**DELEGATED DECISION FOR APPLICATION FOR CERTIFICATE OF
LAWFUL DEVELOPMENT**

Reference no.: 2026/CL/91002/E

Site: 3, Robin Royd Grove, Mirfield, WF14 0LB

Description: Certificate of lawfulness for proposed erection of
workshop/store extension to existing garage

Drg No **26/33/B** Rev

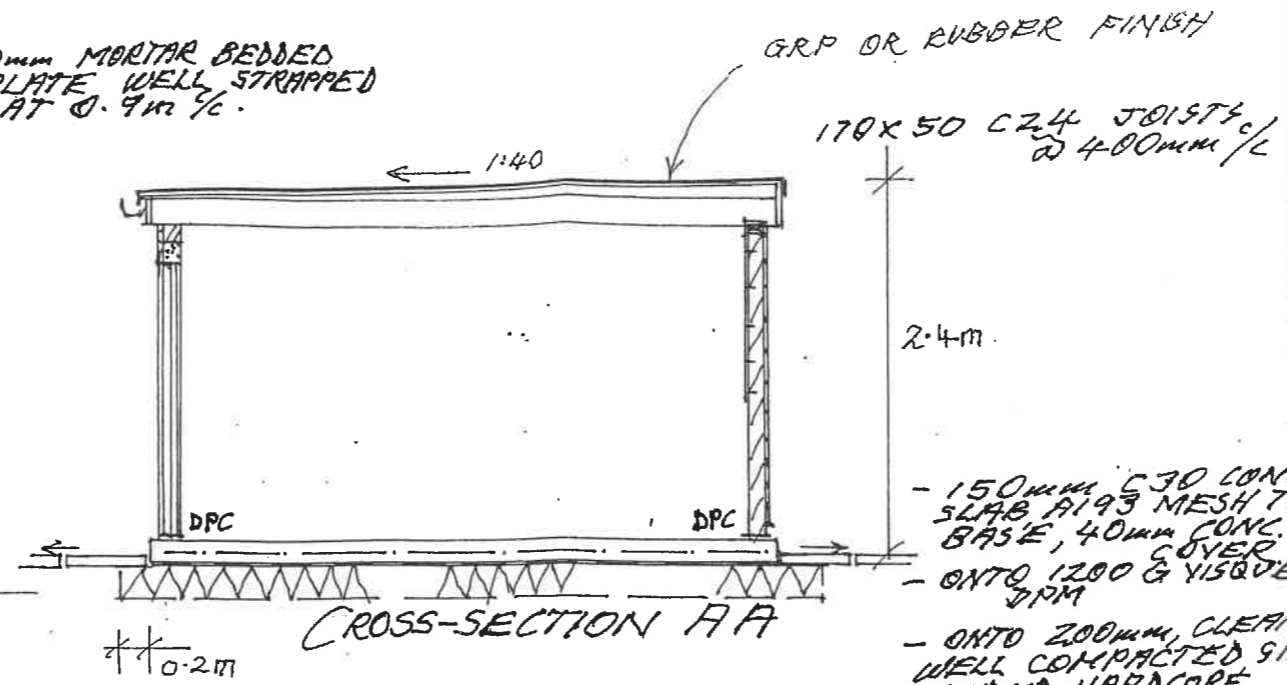
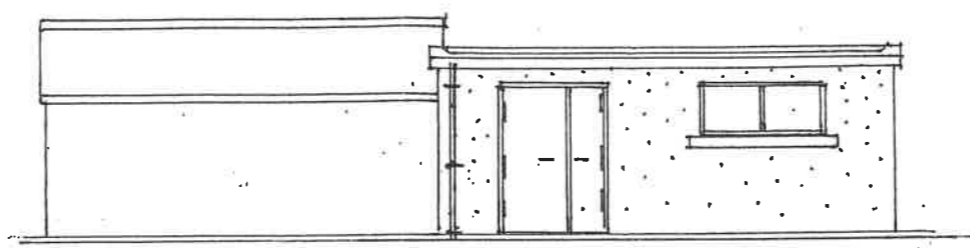
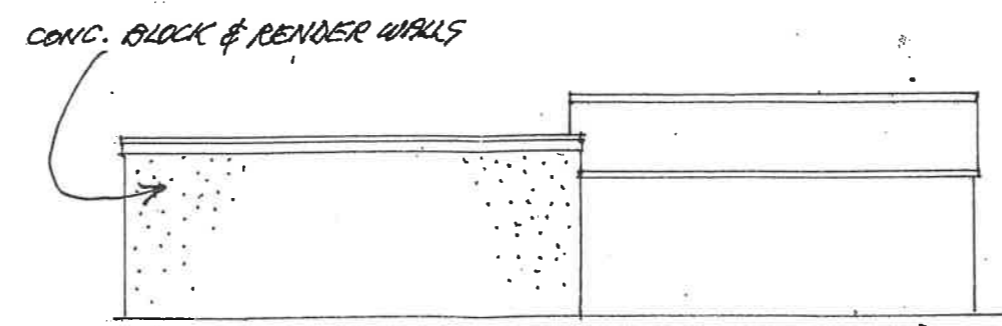
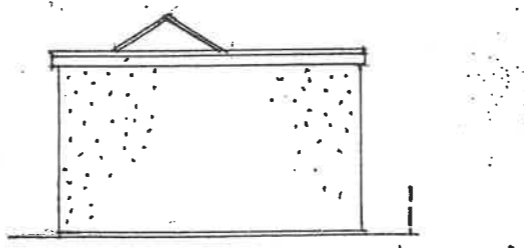
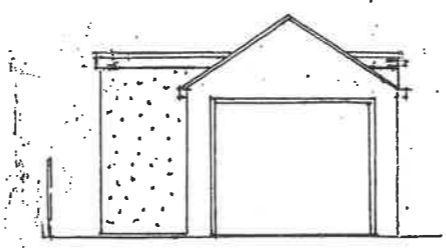
Comment: *The building would have a dual-pitched roof (existing structure) and would be within 2 metres of a boundary. The height of the existing building and therefore the proposed structure would exceed 2.5 metres in height. It is clear on page 43 of the Permitted development rights for householders – Technical Guidance whereby it is stated that ...*

'If any part of the building, container or enclosure is within 2 metres of the boundary of the curtilage of the house, then the height limit for the total development is restricted to 2.5 metres if it is to be permitted development.'

The proposed extension to the existing garage does not benefit from a general planning permission granted under Schedule 2, Part 1, Class E of the Town and Country Planning (General Permitted Development) (England)

Order 2015 (as amended) as it would be contrary to paragraph E.1 (e) of the same Order.
